From: Jane Curran <jane.curran@nrar.nsw.gov.au>
Sent: Monday, October 19, 2020 3:34 PM
To: Bonjer, David <DavidB@ecoaus.com.au>
Cc: Jeremy Morice <jeremy.morice@dpie.nsw.gov.au>
Subject: RE: 200 Aldington - consultation with NRAR

We have been assisting the Trustee for Fife Kamps Creek Trust with their project at 200 Aldington Road, Kamps Creek. This is a State Significant Development (SSD 10479) for a concept plan comprising 13 development lots, internal roads, bulk earthworks and utilities. The SEARs require consultation with DPIE Water Group including NRAR. Whilst a full riparian assessment will be lodged with the SSD application, this email contains a basic description of the site and the proposed project for the purposes of initial consultation.

**BULK EARTHWORKS AND
STORMWATER DRAINAGE
PLAN
SHEET 1**

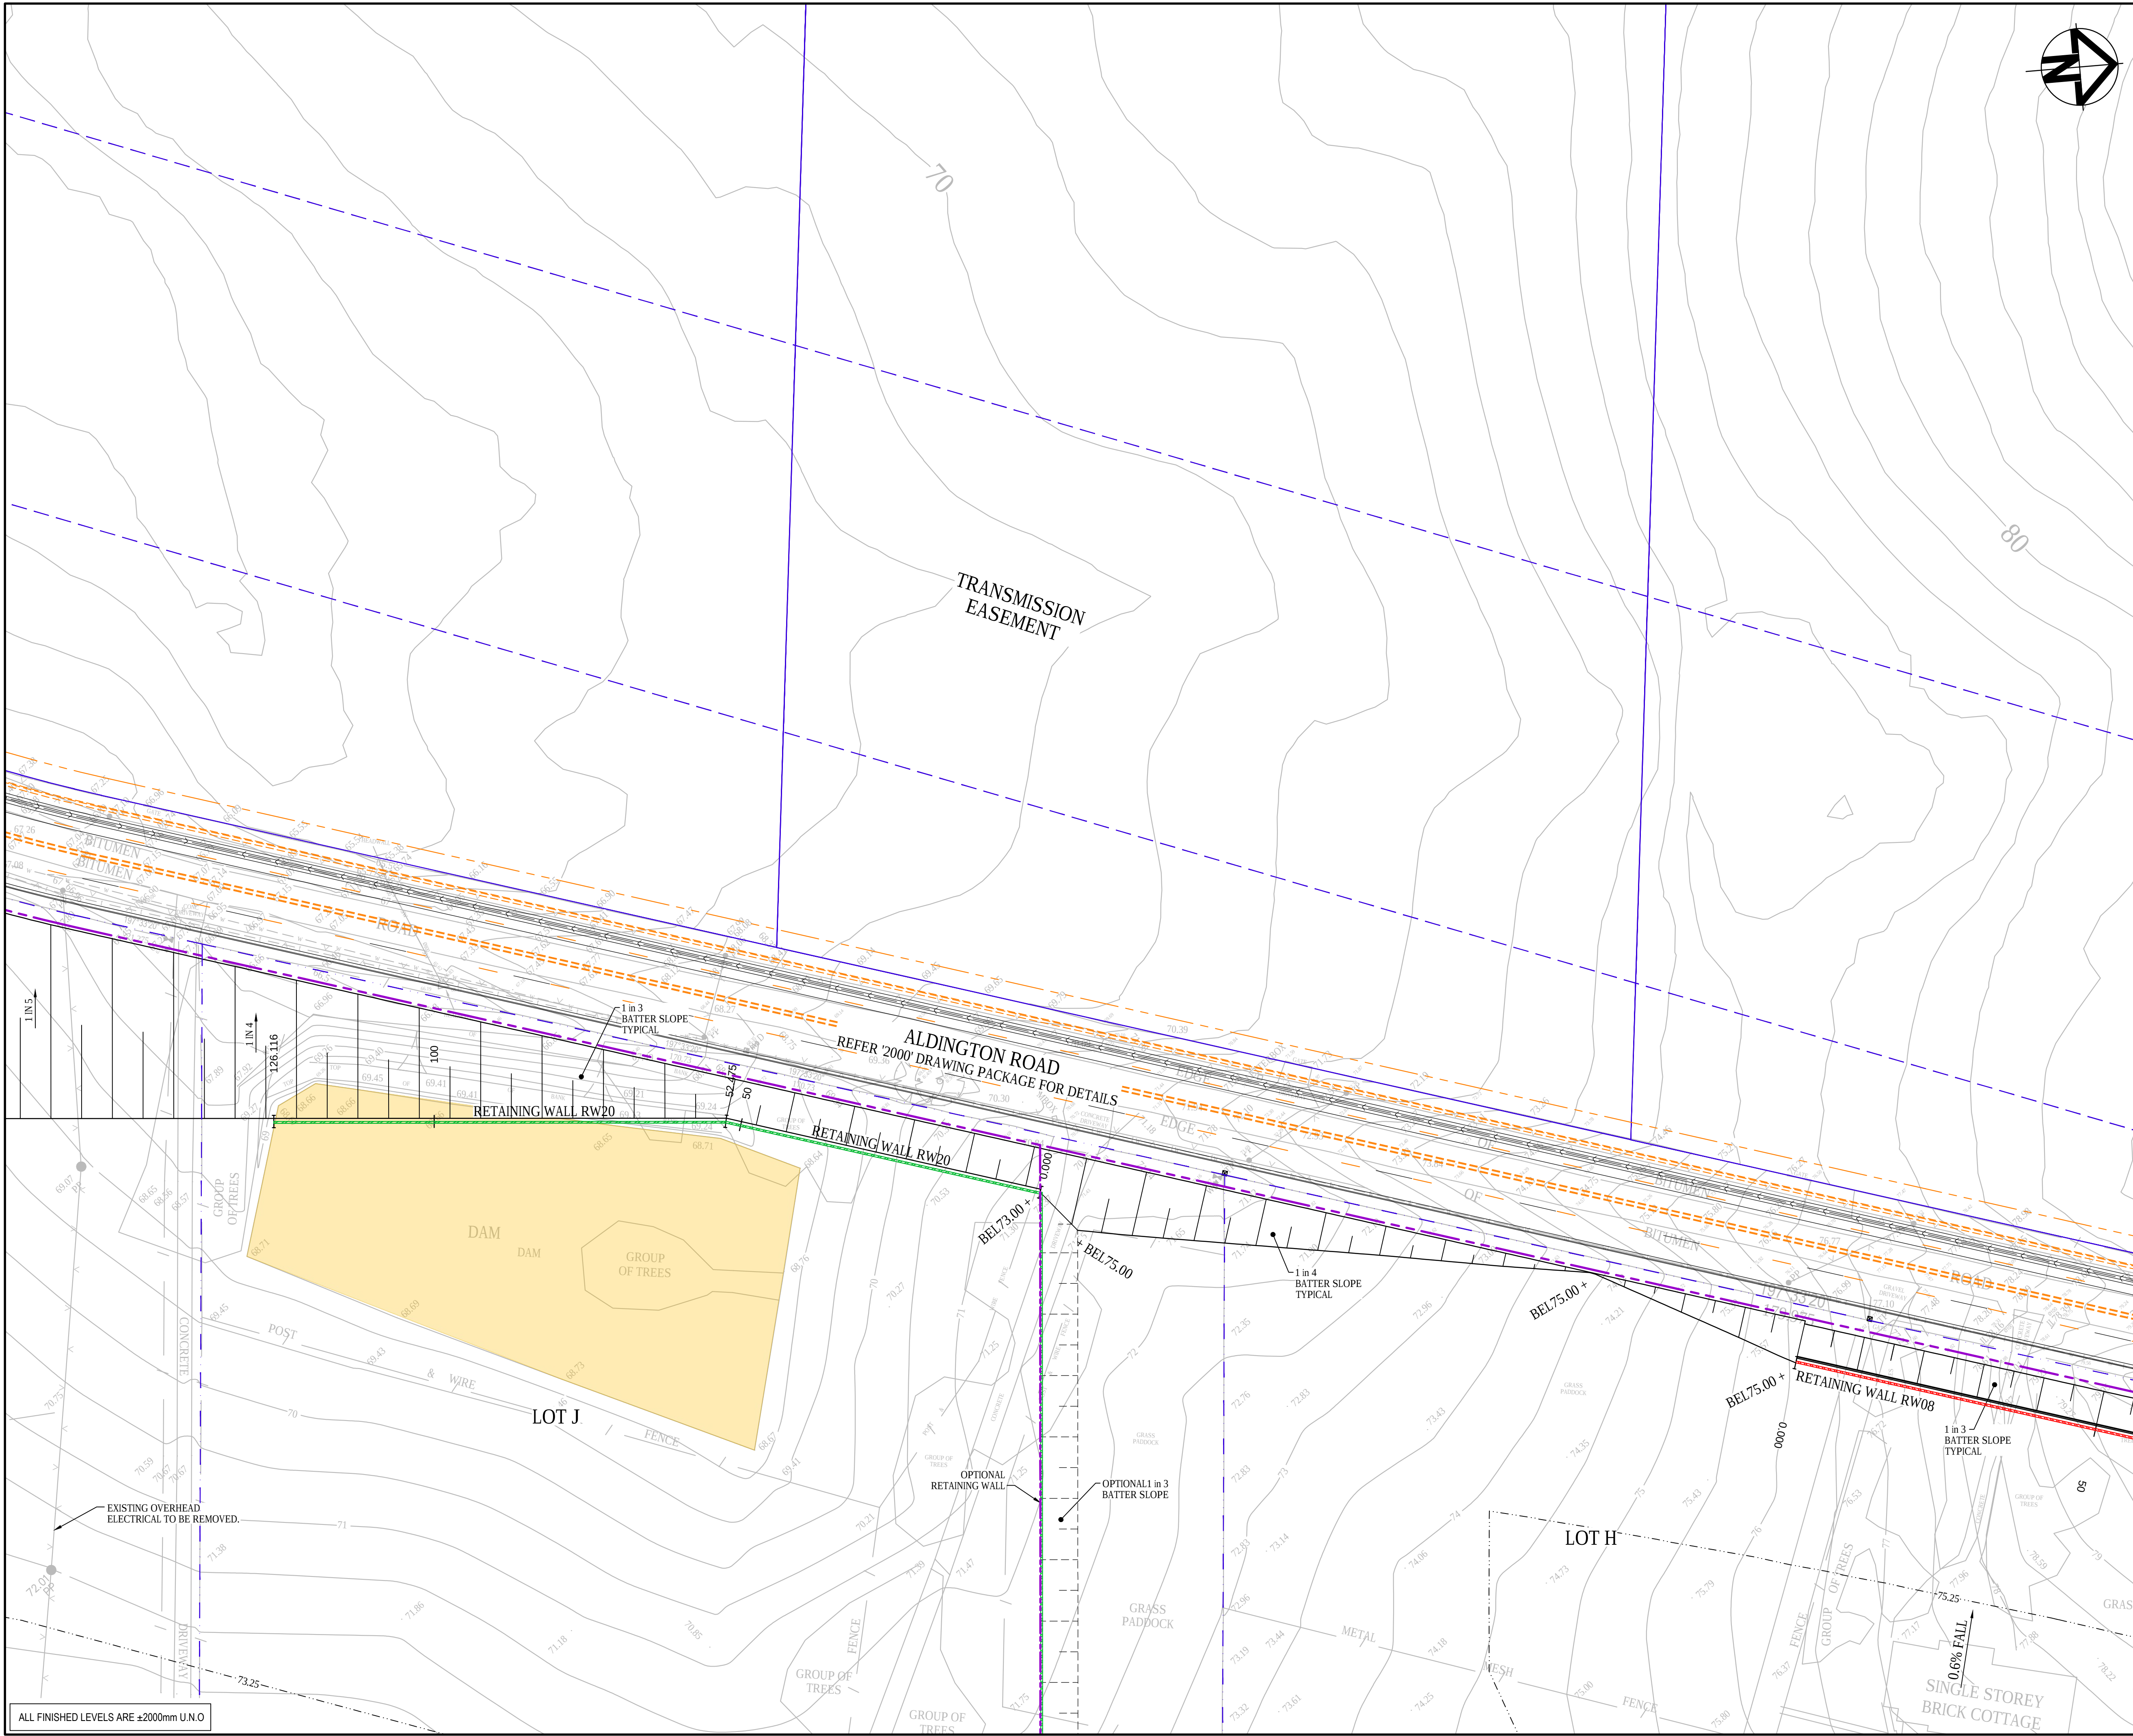
- The information below shows the planned realignment of the watercourse towards the east through an identified wetland area and then into Ropes Creek. Based on the information provided to NRAR, we would not support the realignment of the watercourse as it does not comply with the Mamre Road Precinct Structure Plan – June 2020. The project must also assess post-development impacts on the watercourse and the adjacent wetland area.

- NRAR recommends that flood detention requirements be considered and suitable locations for basins be allocated early in the planning process. Planning should be contacted in regards to flood detention at this site and how it will be incorporated into the overall Precinct area given the below plans indicate the dam may be filled in.
